**Transport
for NSW**

Exhibition of Mixed Use Residential, Retail, Commercial and Hotel Development at Block 4N and modification to the approved Concept Plan at Central Park, (former Carlton United Brewery site)

Thank you for your letter dated 14 November 2014, requesting Transport for NSW (TfNSW) review and comment on the development application and modification for the above proposals.

Block 4N
Ground Floor
FFL +13.70

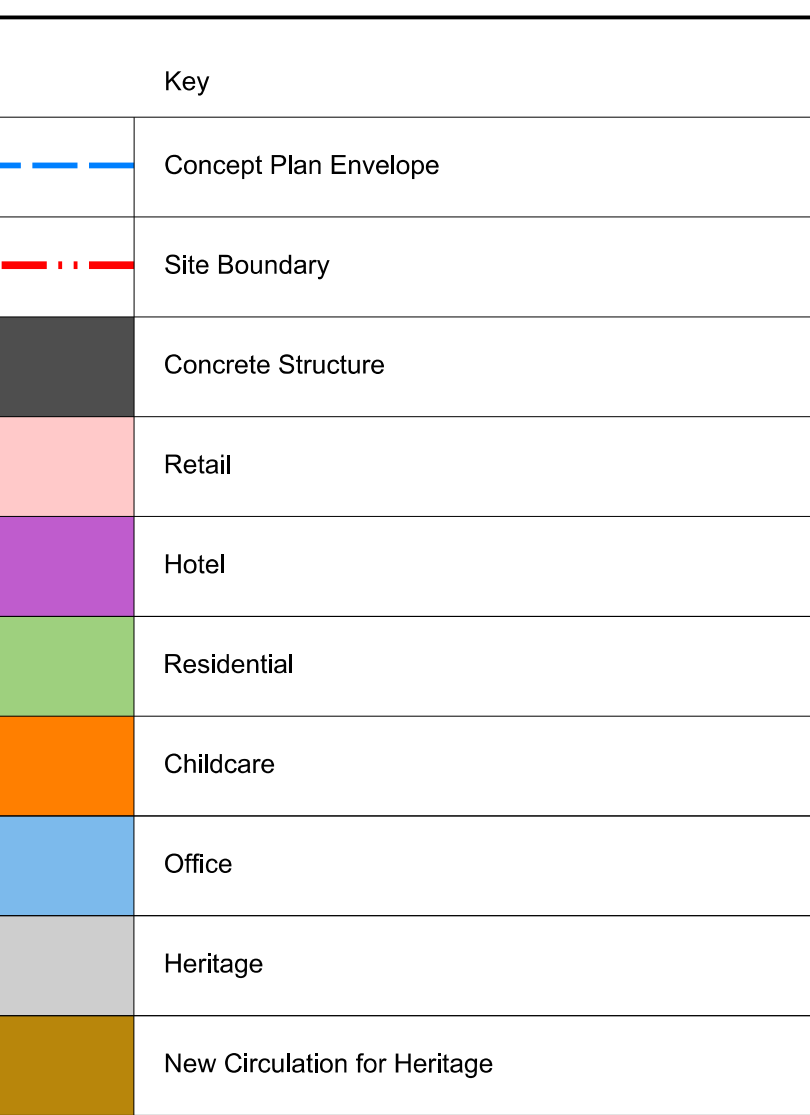
- The location of bike parking should not be located within or near the reverse manoeuvre paths of vehicles.
- Visitor bike parking should be placed on the ground level, located in areas visible and close to the main entry incorporating adequate lighting and passive surveillance. TfNSW would prefer that visitor bike parking not be provided below ground level, as visitor spaces located on basement levels may not be utilised as intended due to restricted accessibility and limitations of way finding.

Block 4N Staging Plan

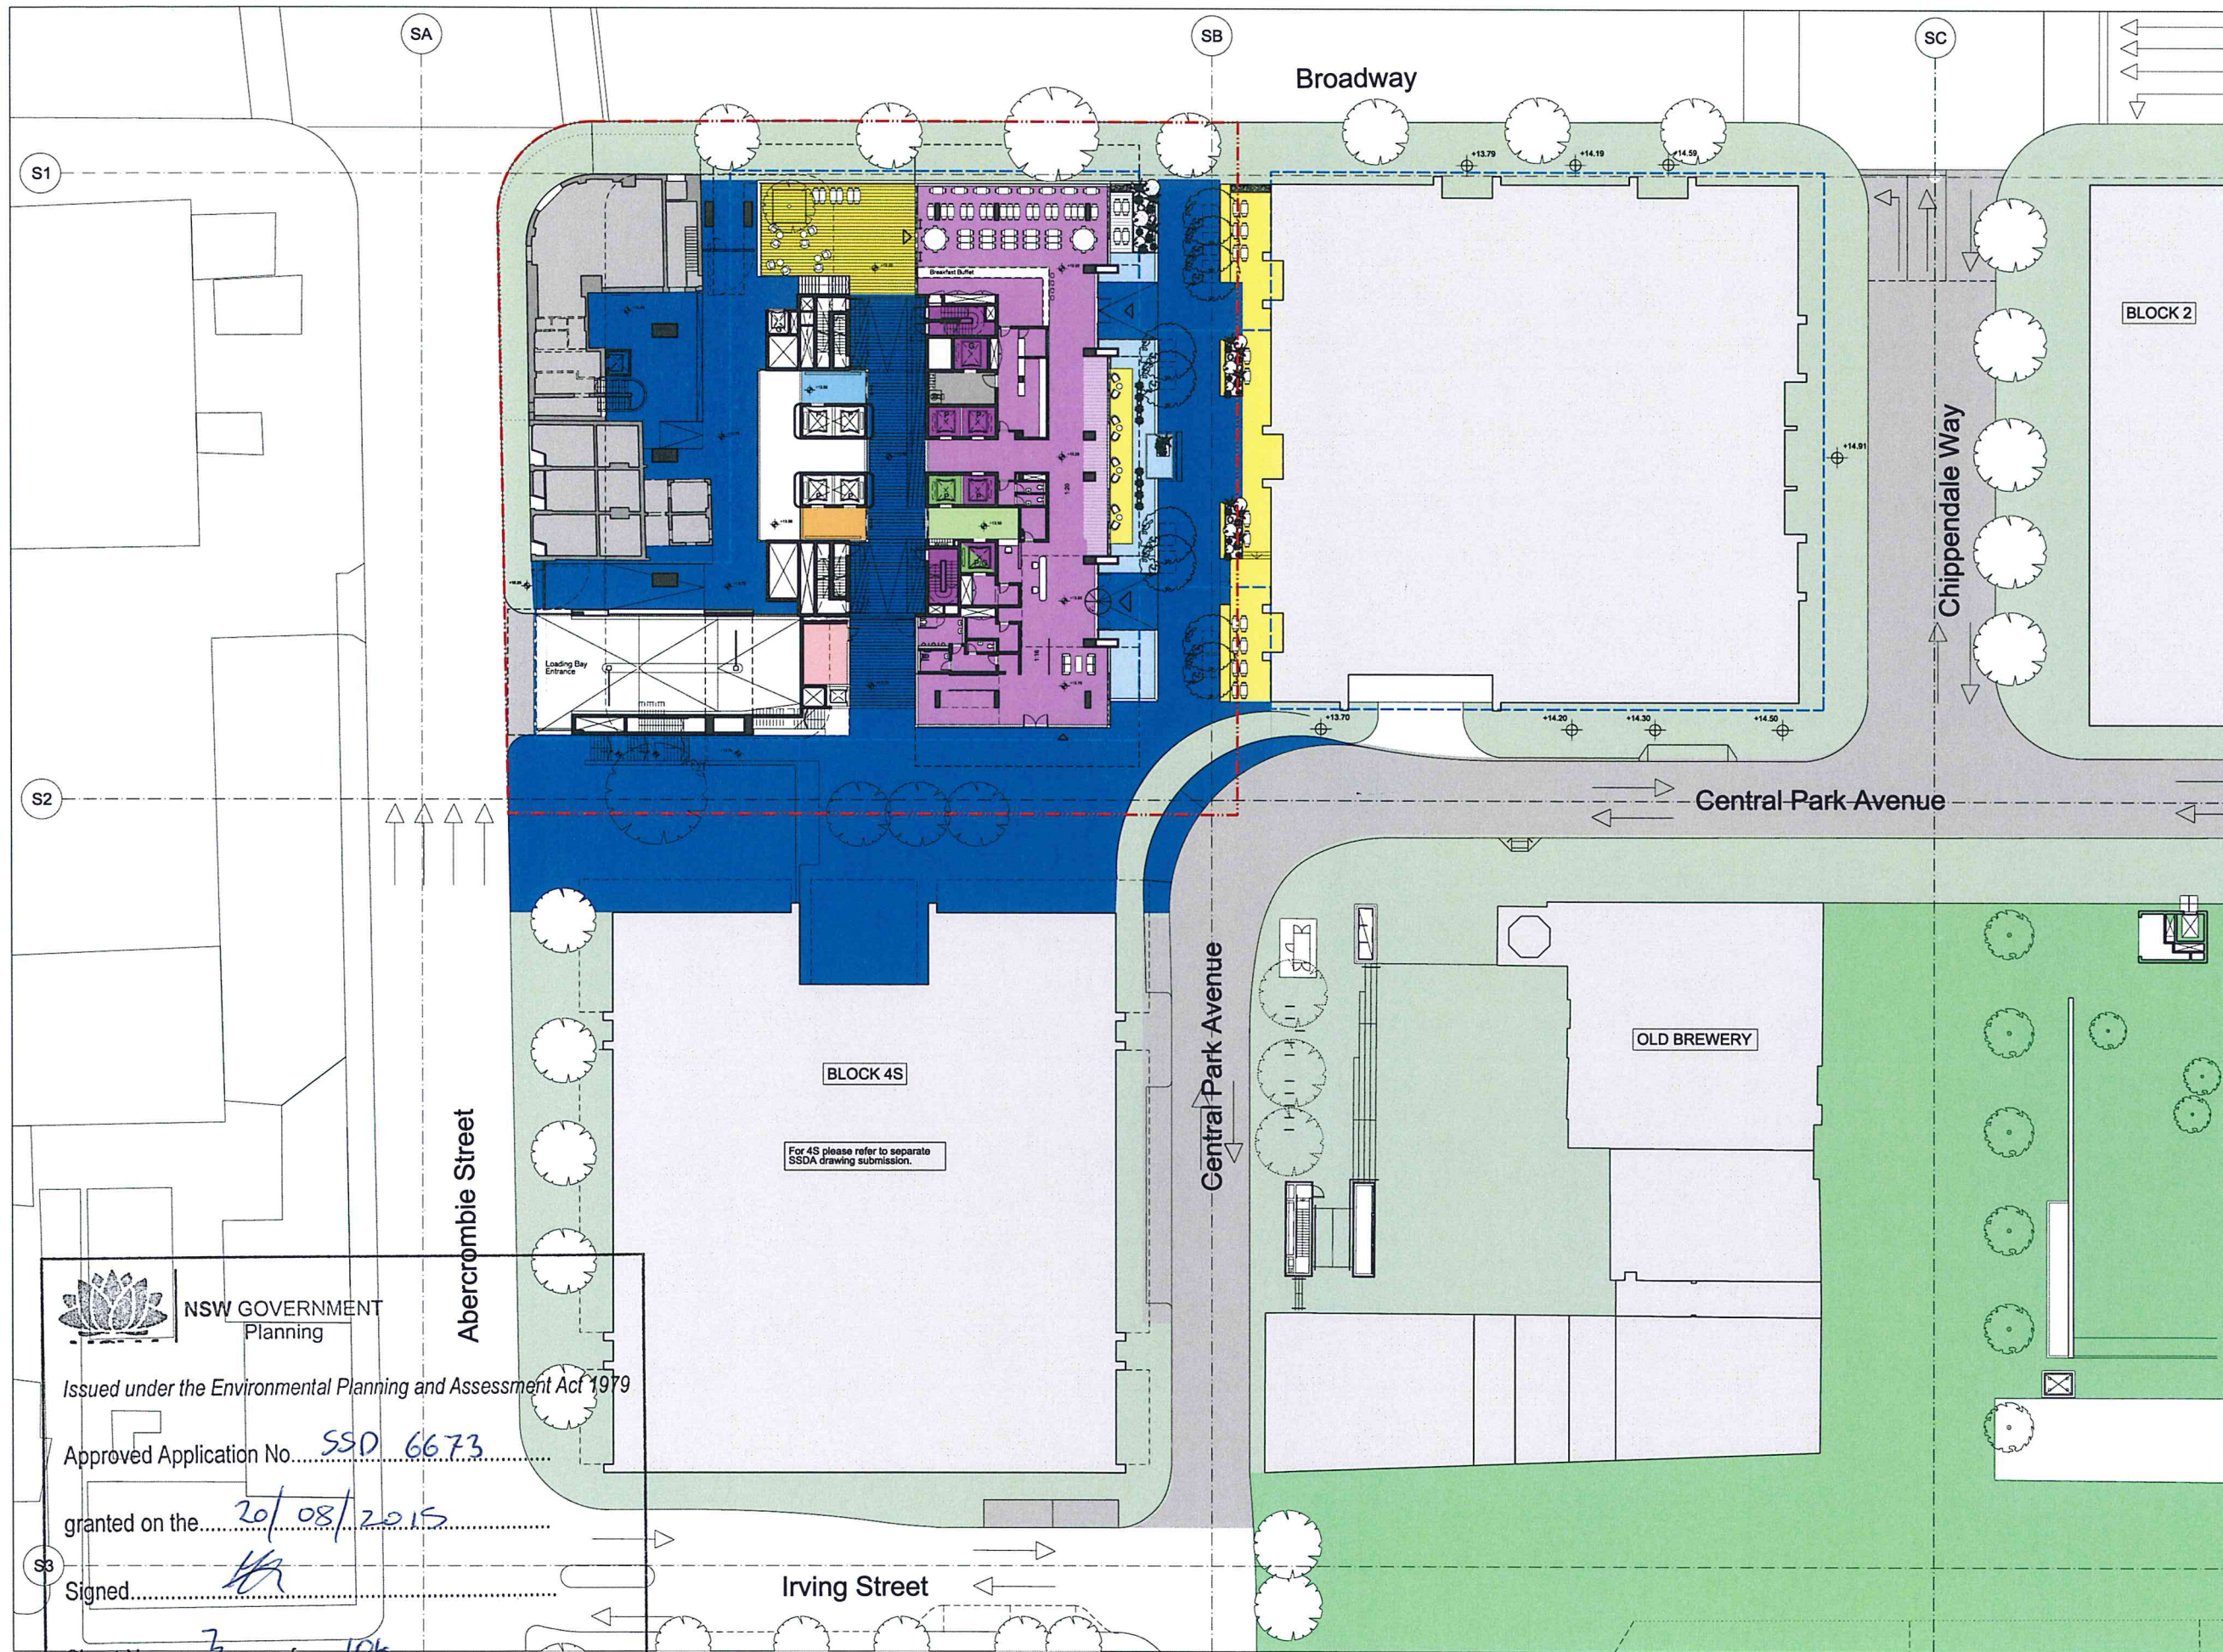
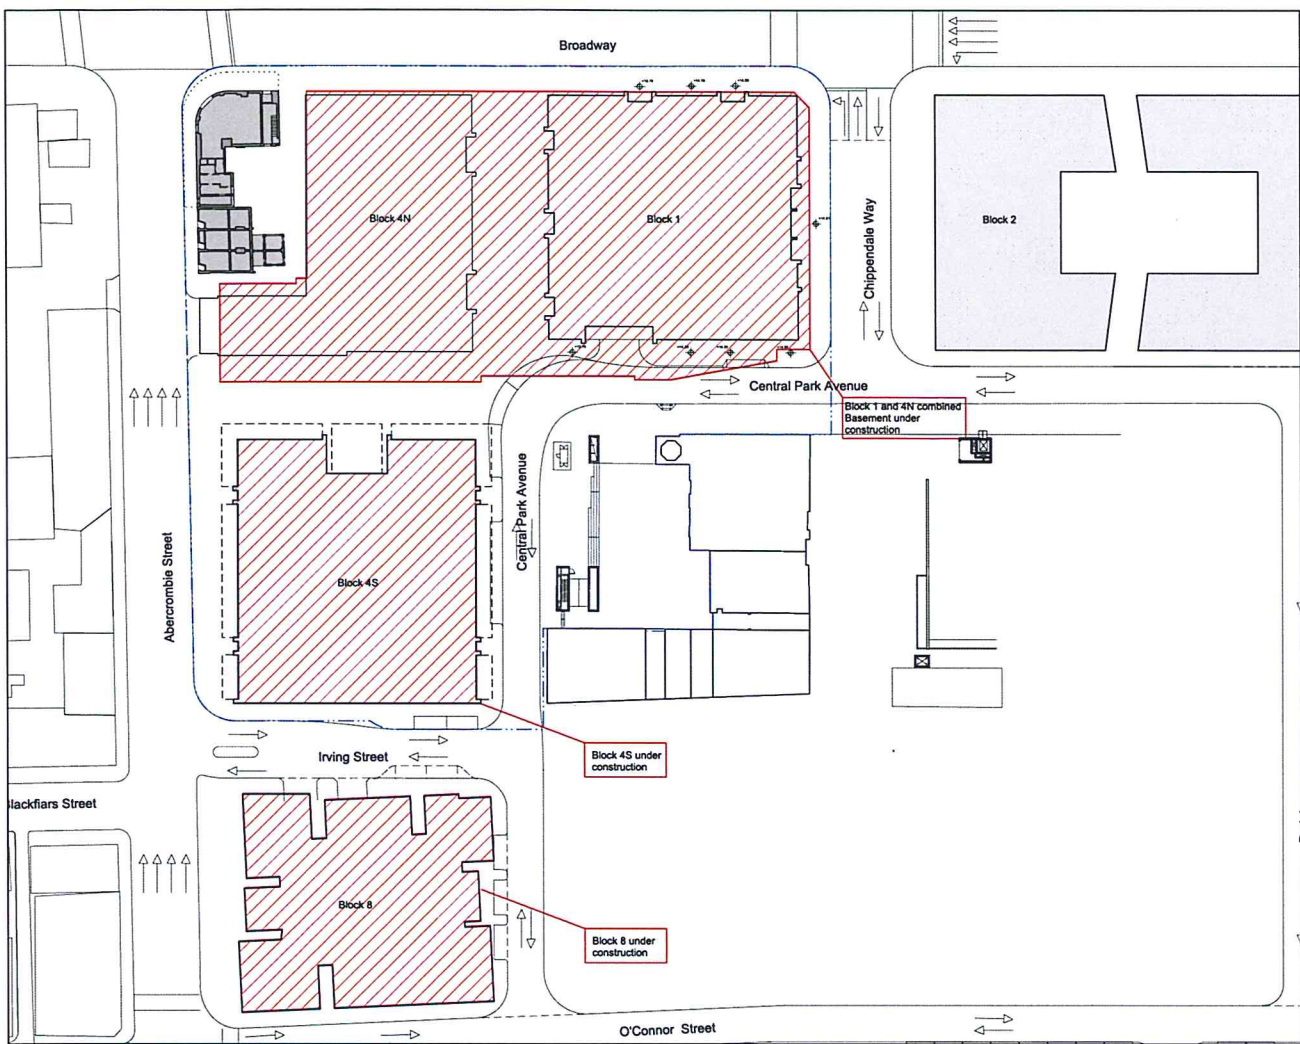
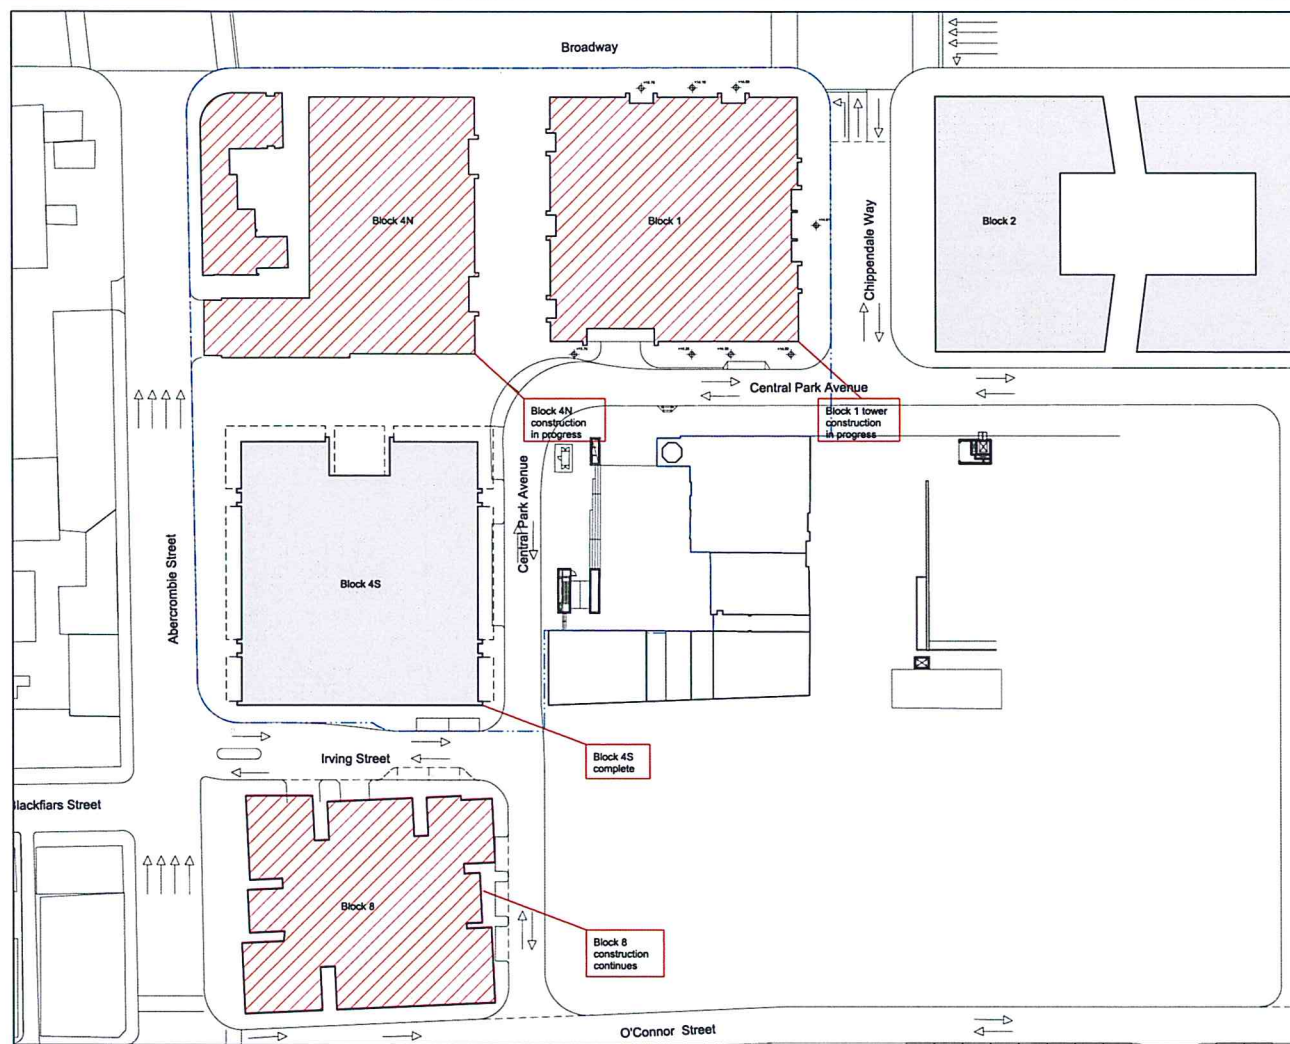
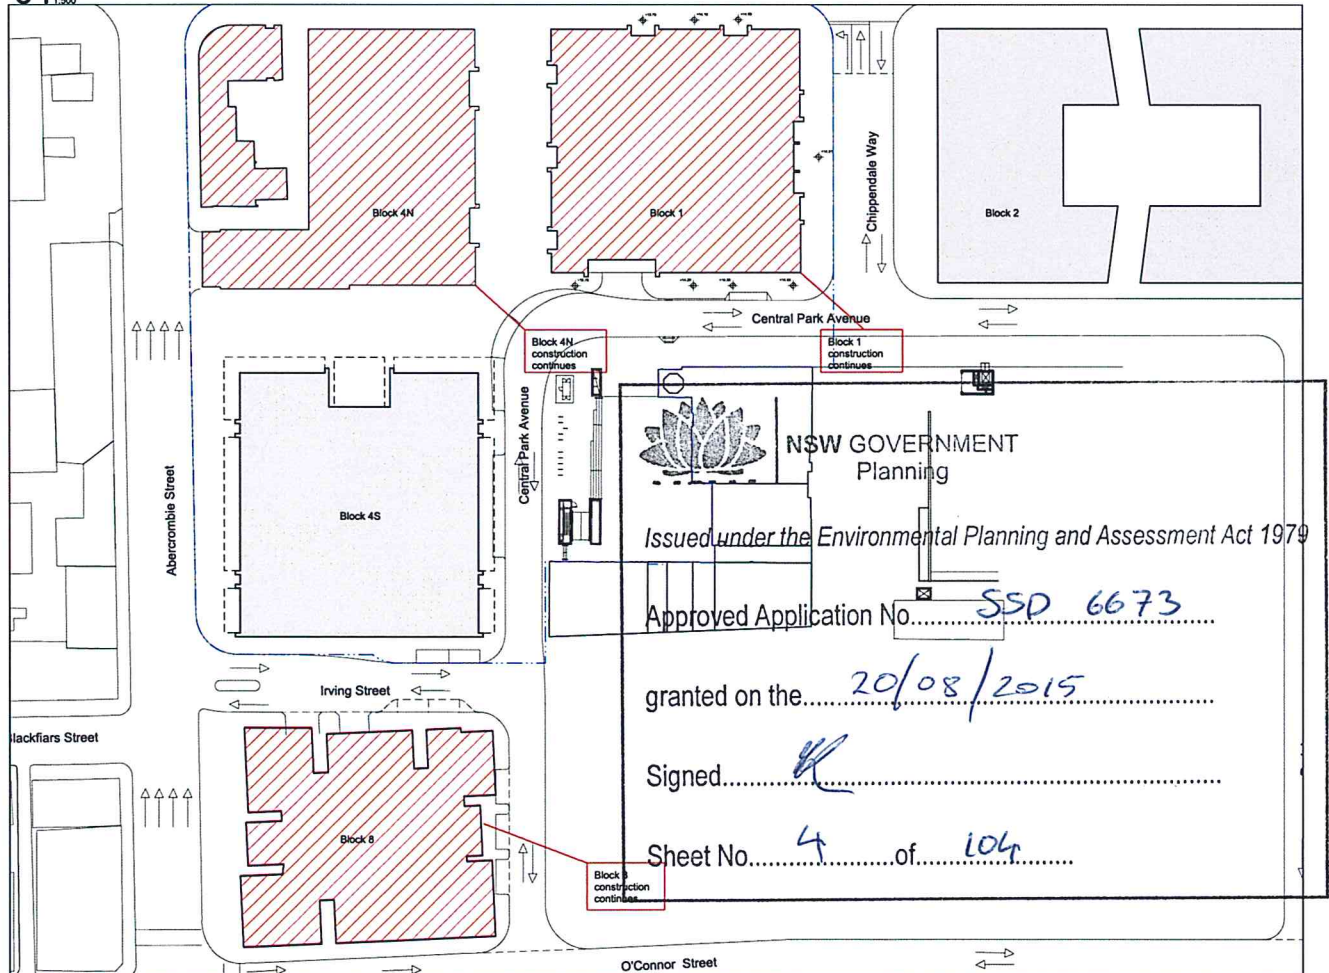
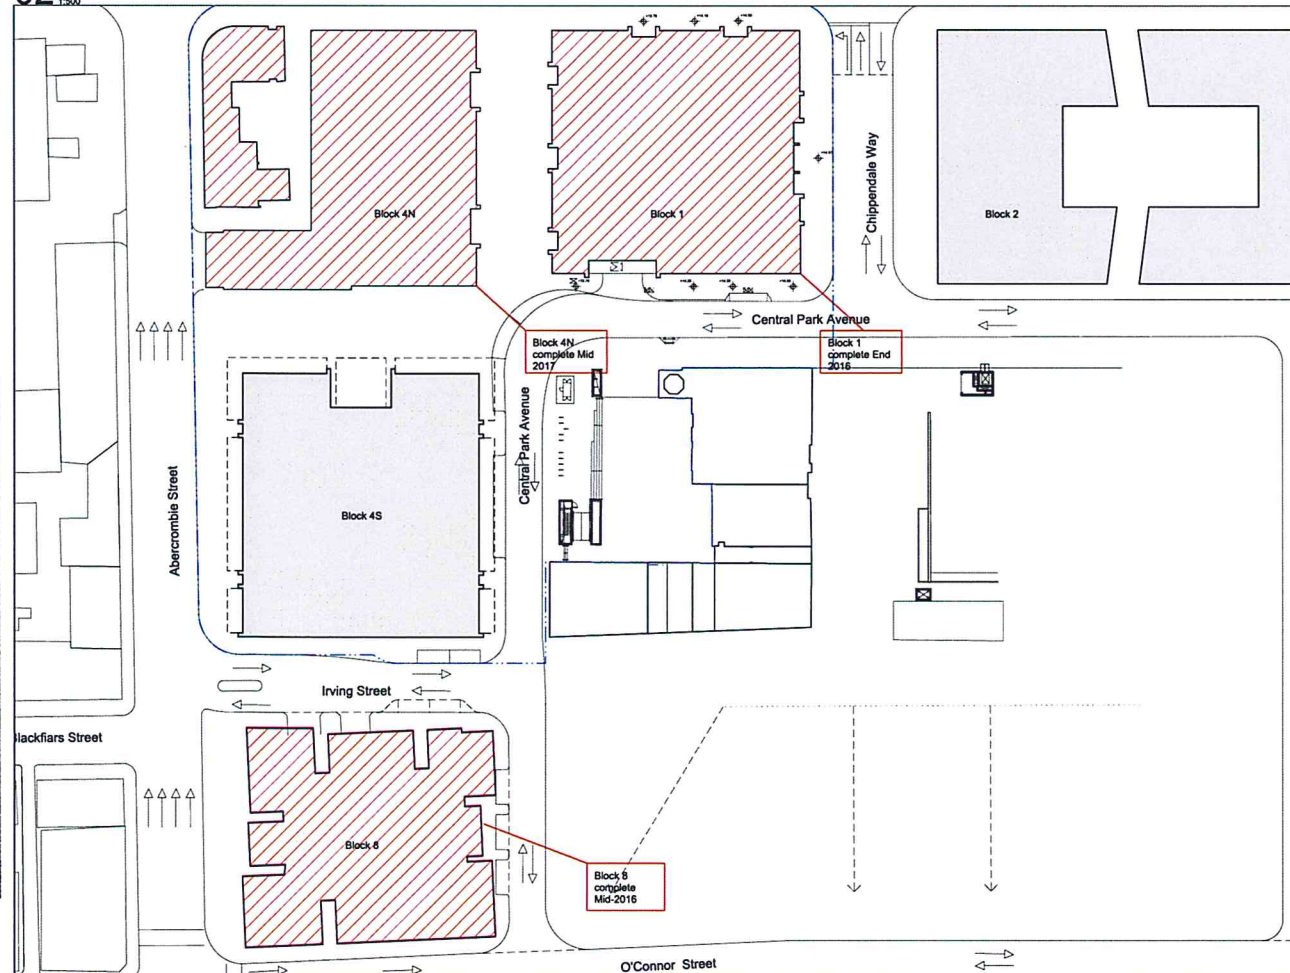
- The Construction Traffic Management Plan should include a requirement that pedestrian and cycle movements will be maintained along footways and cycleways at all times. Should construction activities require closure of either facility, adequate safety and diversion measures should be put in place to minimise time delay and detour distances.
